17 December 2020

Our Ref: R/2019/20/A
File No: 2020/564775
Your Ref: SSD-10384

Request for Advice – Sirius Redevelopment – 2-60 Cumberland Street, The Rocks (SSD 10384)

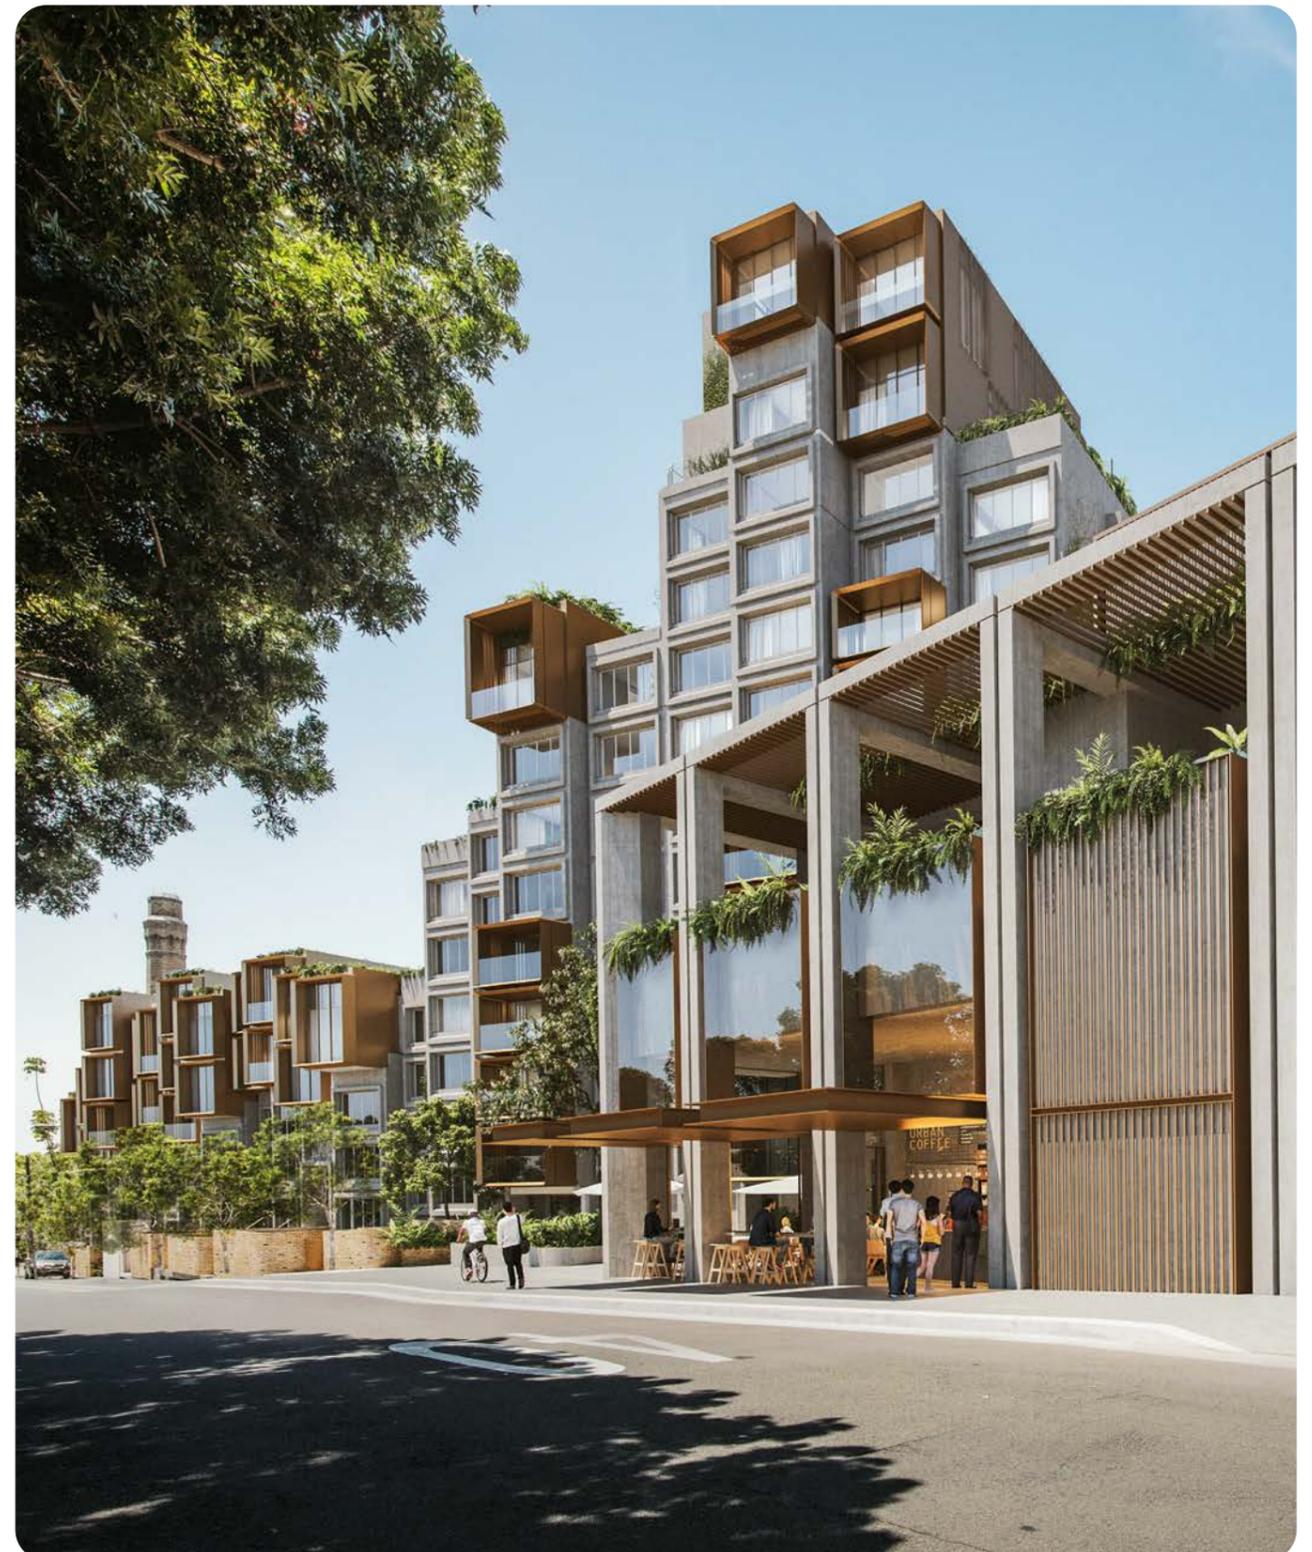
There are some gradients across Gloucester Walk that direct stormwater towards the internal lifts in the development, which are below the footway level. Details have not been provided to illustrate how this water is intercepted. The levels for vehicle access from the southern end from Cumberland Street are unclear. Further details are requested to identify any access and stormwater issues.

NORTHERN POCKET PARK

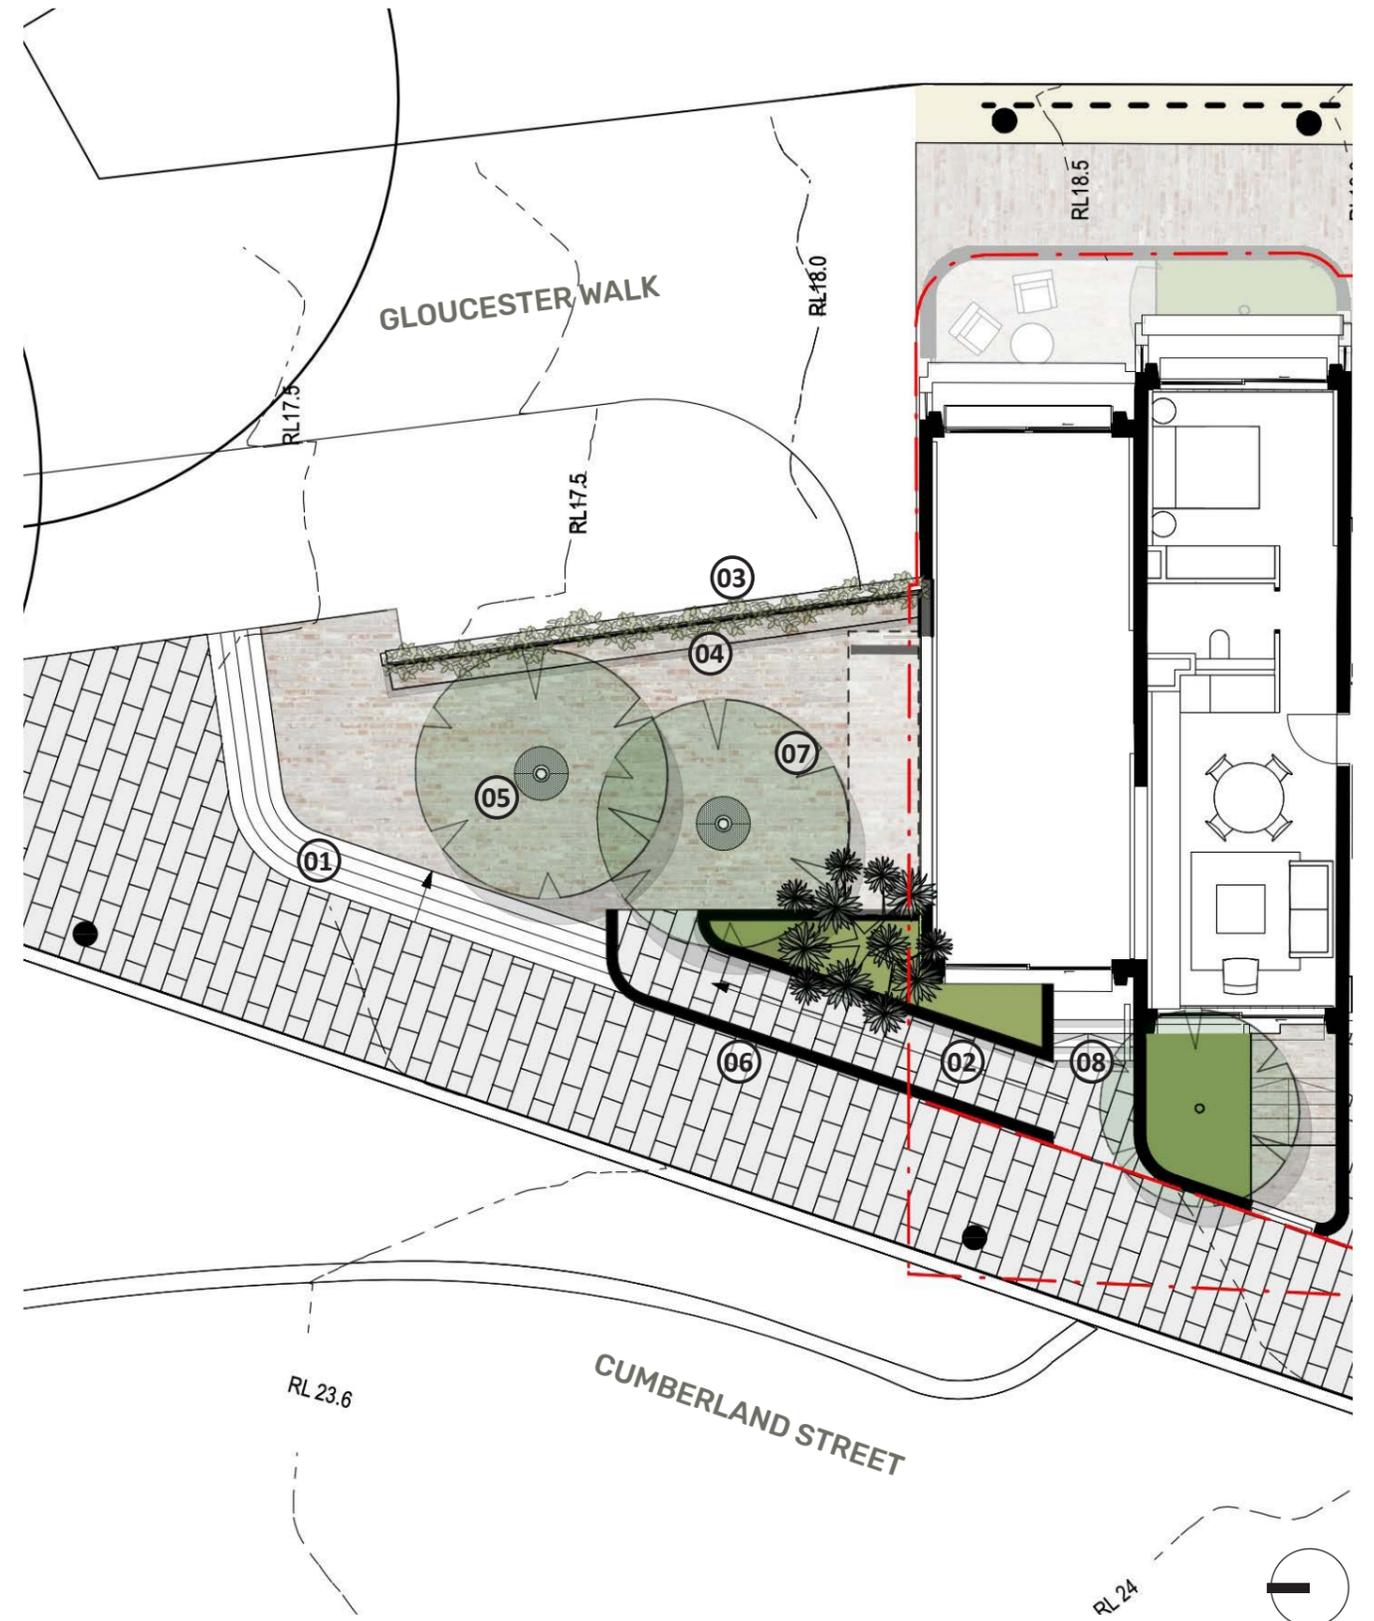
The relationship between the motorcycle parking at the north end of Cumberland Street has some trip hazards. It is neither road nor footway and could be better integrated the development. Further, the terrace and open space at the north end of Cumberland Street seems unclear as to its connection to adjacent spaces. The proposed ramp could have a more open frontage to the street rather than being concealed behind a wall.
